DOC20/374553
SSI-10038

State Significant Infrastructure proposal - Sydney Metro West (SSI-10038)

I refer to the request for Environment, Energy and Science Group (EES) advice on the Environmental Impact Statement (EIS) for the above.

Figure 22-2: Location of plant community types within the Stage 1 footprint

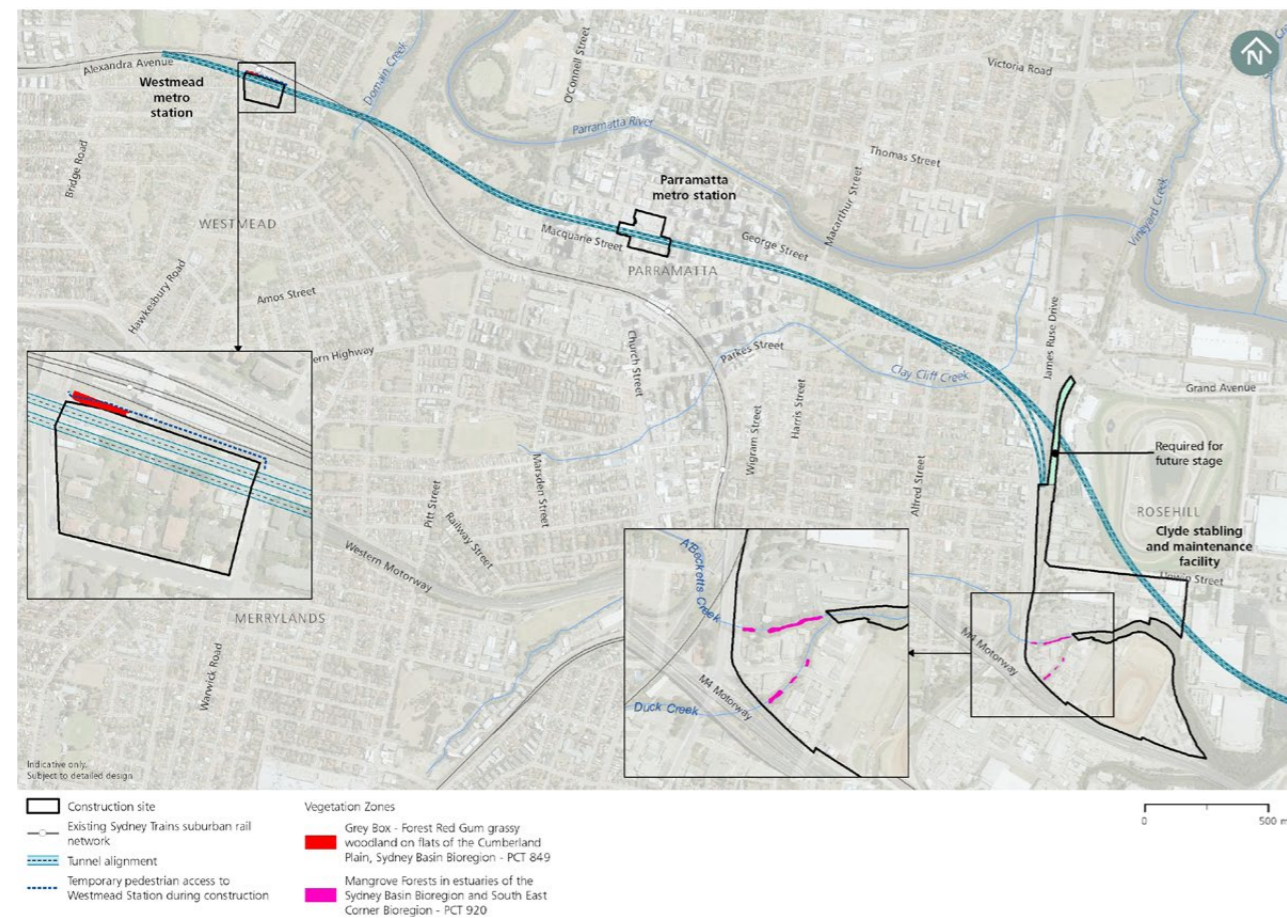
- In relation to Plant Community Type (PCT) 849, the BDAR states '*plant roots will be in the silty clay soils separated from the zone of drawdown by the lower permeability shale layer*' (page 58, Table 4-6). However, given the structure and composition of this PCT, it is highly

Figure 9-18: Clyde road and creek realignment works

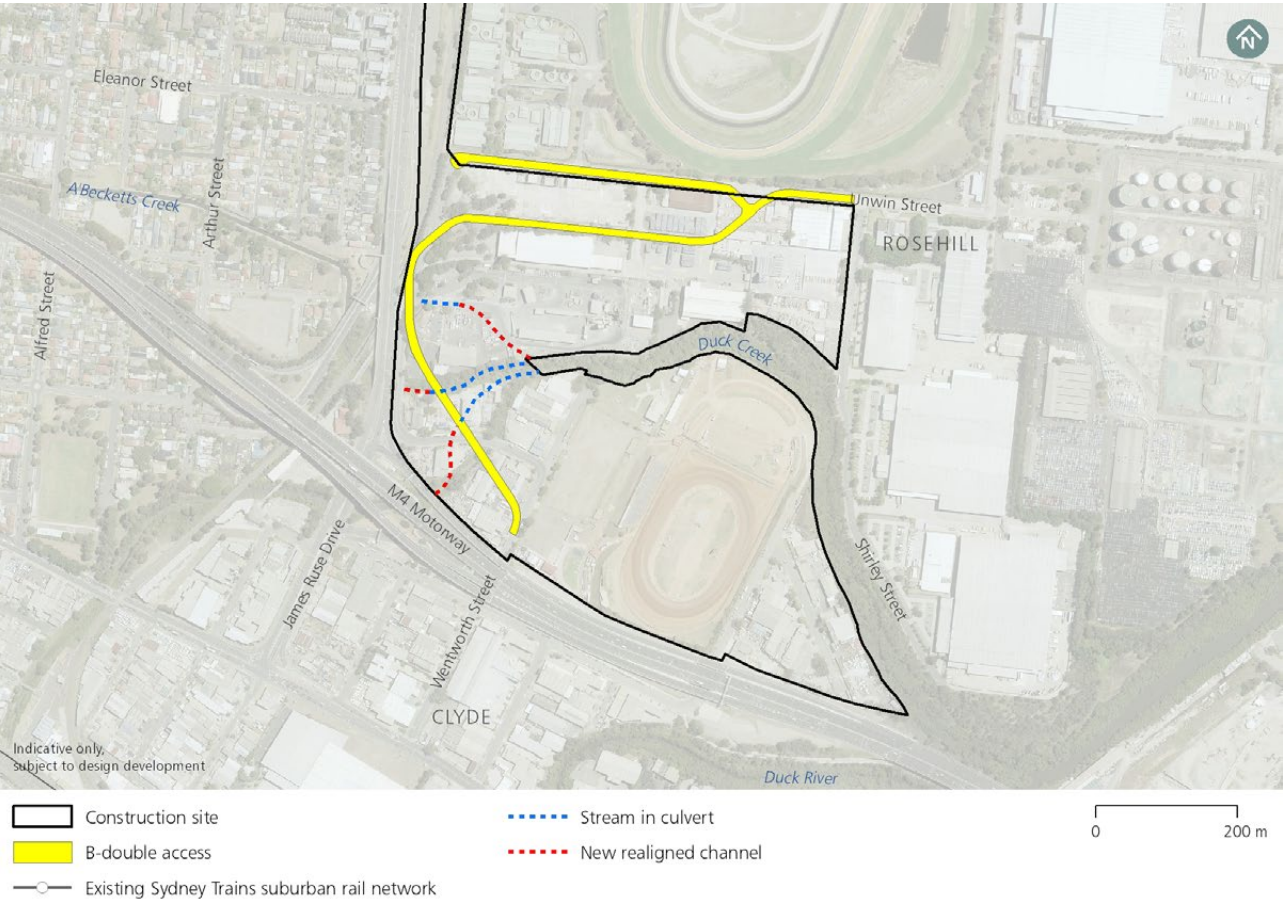
- Mitigation Measure B2 - The incorporation of a vegetated riparian zone into the realigned sections of A'Becketts Creek and Duck Creek, and that this is addressed in the Flora and Fauna Management Plan which includes a planting schedule with representative species from PCT 920 (Mangrove Forests in estuaries of the Sydney Basin Bioregion and South East Corner Bioregion).
